ENG-SP19003-R4-PrelimPlan-redlines.pdf Markup Summary

Subject: Text Box
Page Index: 1
Date: 2/8/2021 11:01:22 PM
Author: dsdrice
Color: ■
Layer:
Space:
Page Label: [1] 1 21187-01CV1 - DP01

PP05

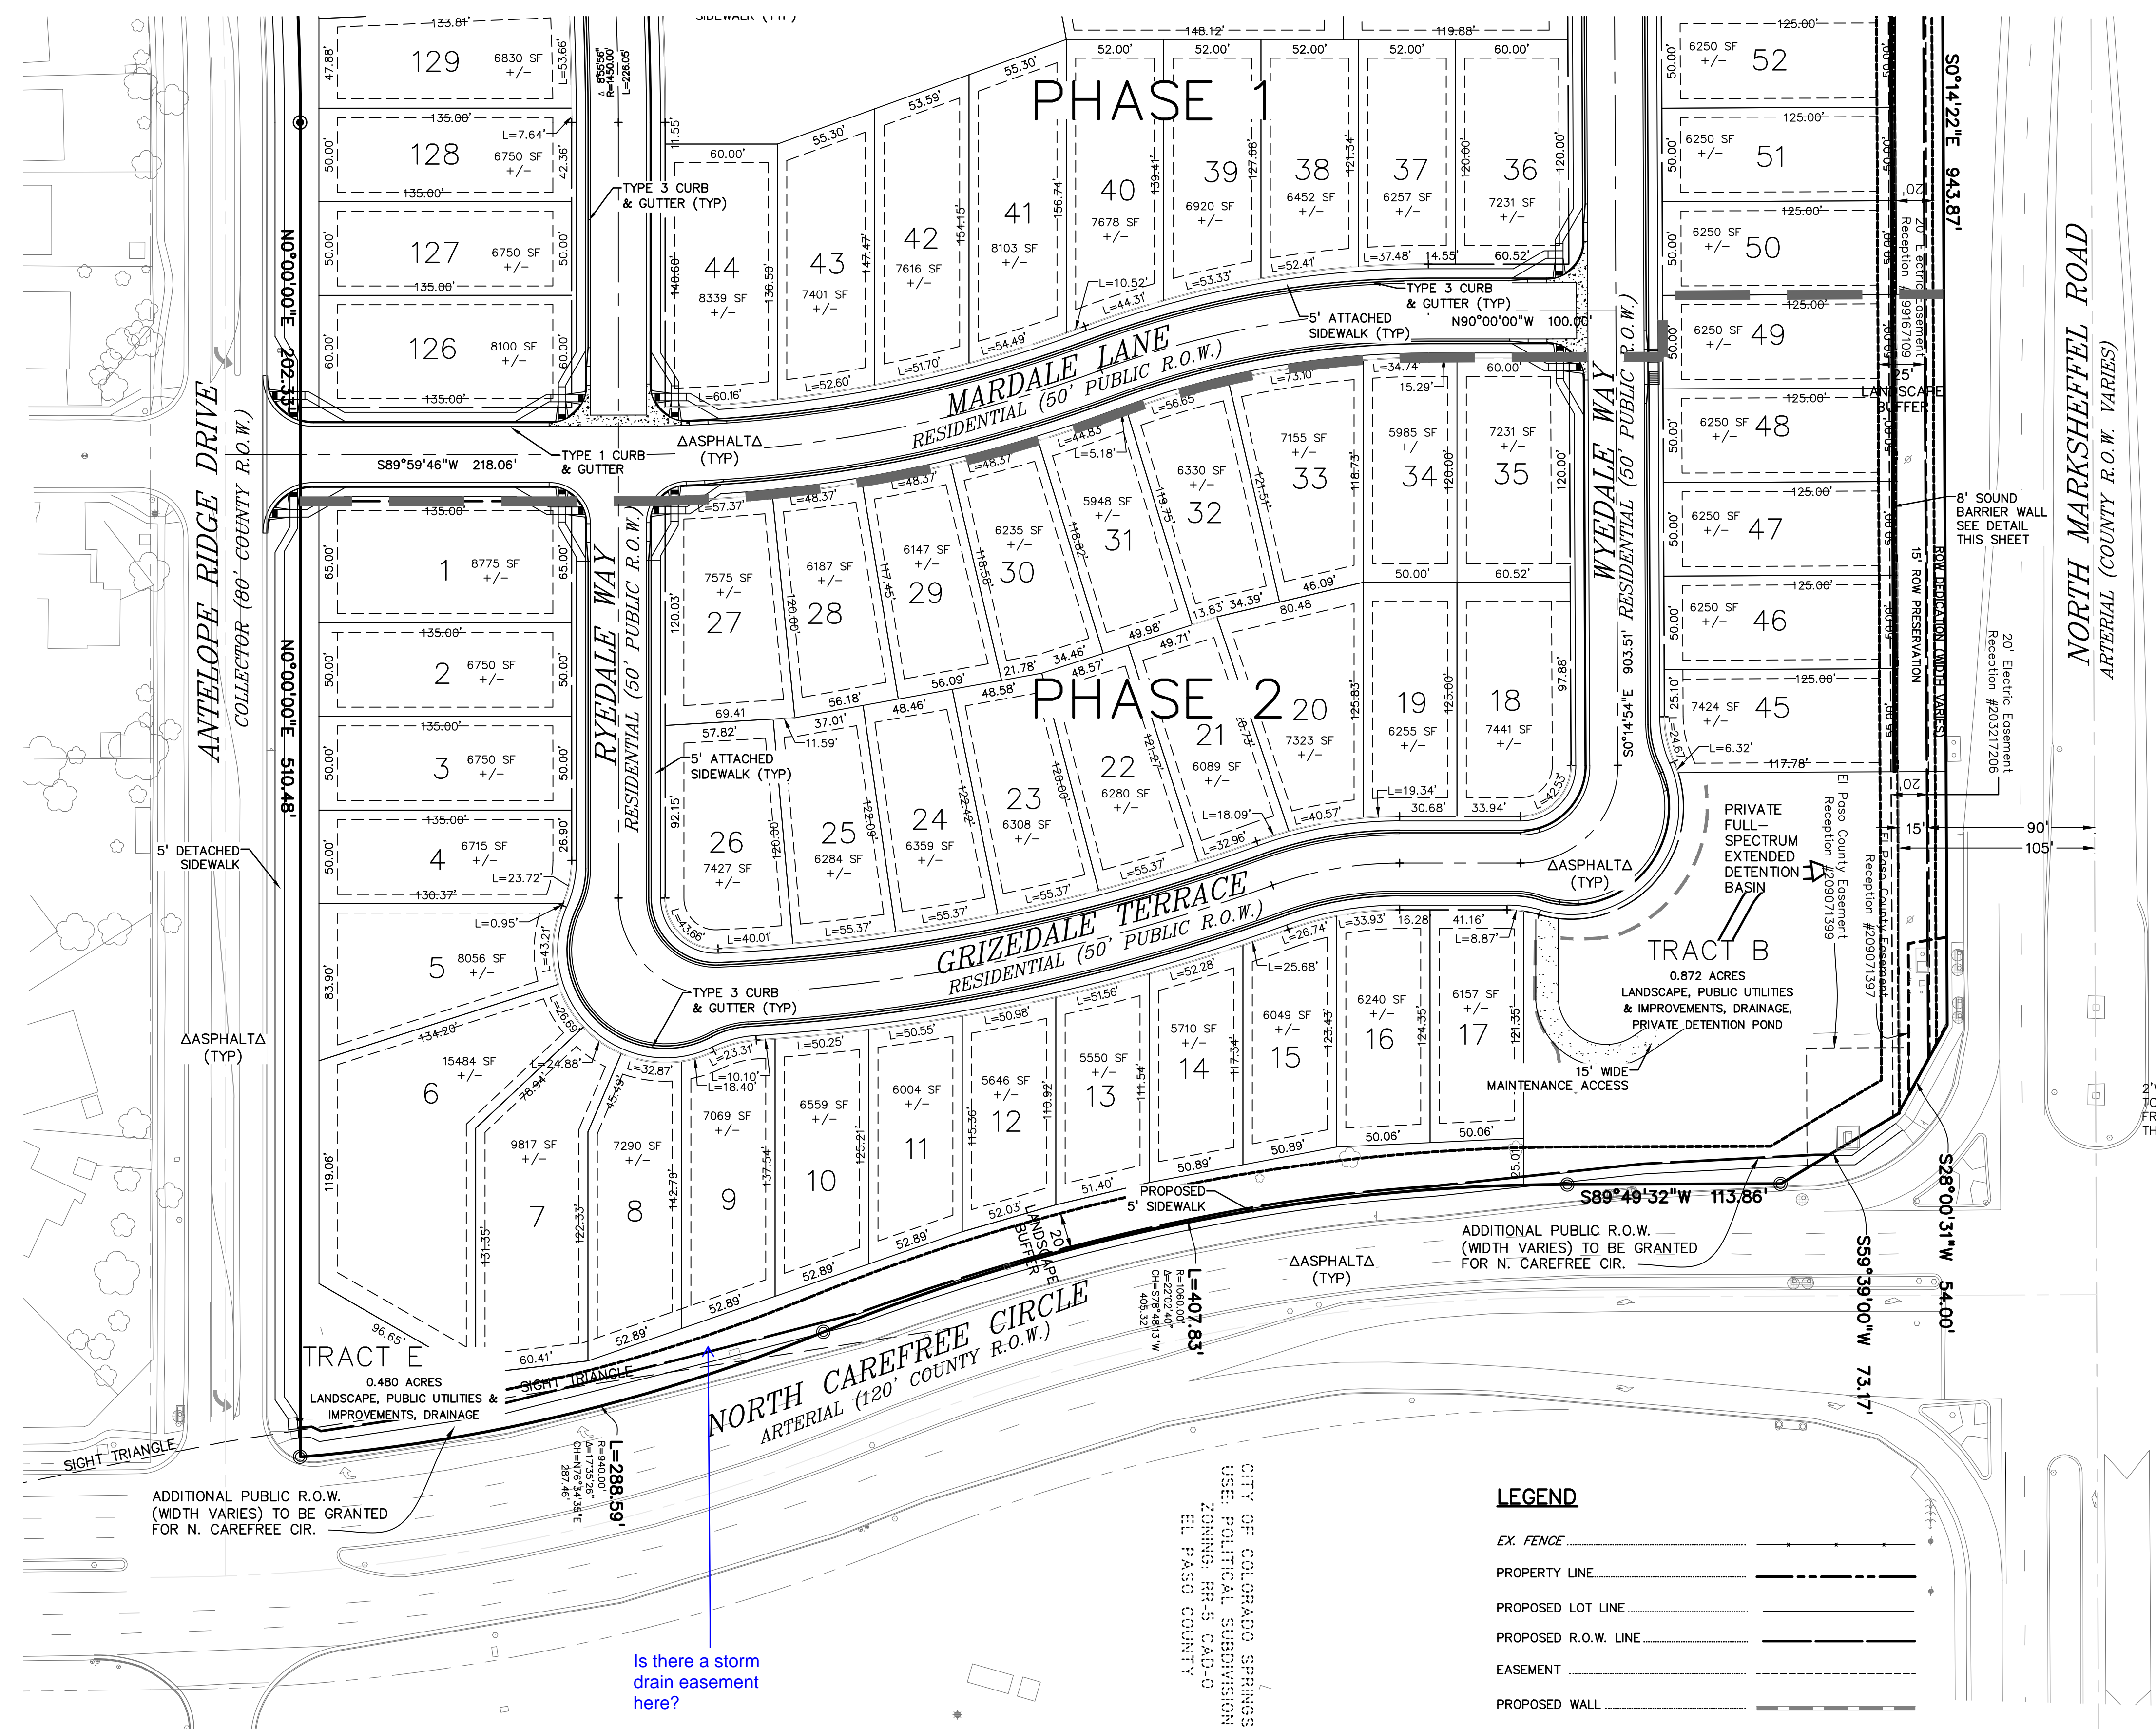
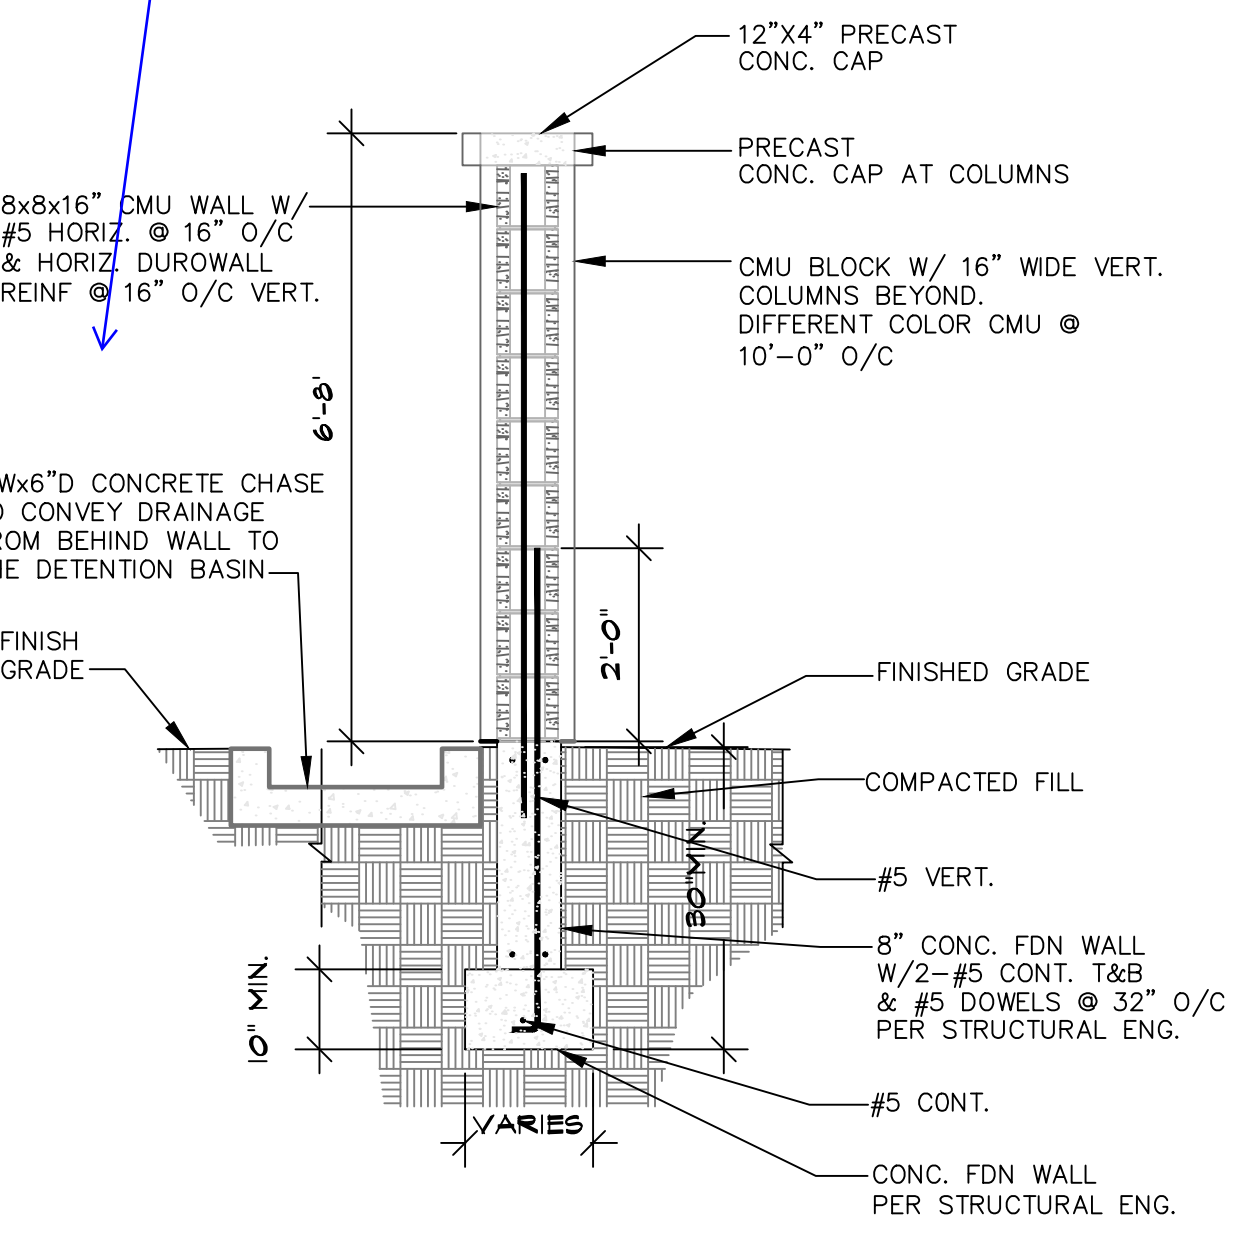
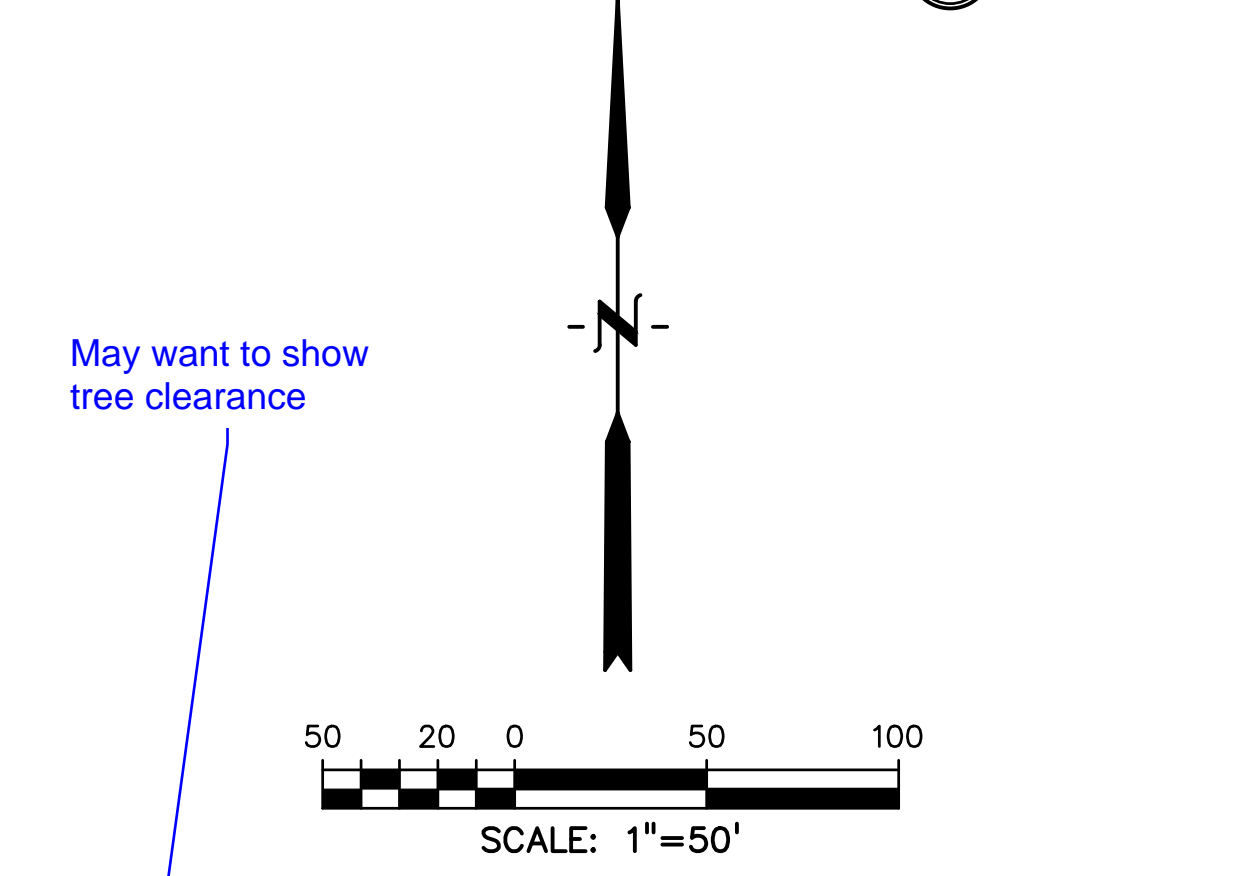
May want to show tree clearance

Is there a storm drain easement here?
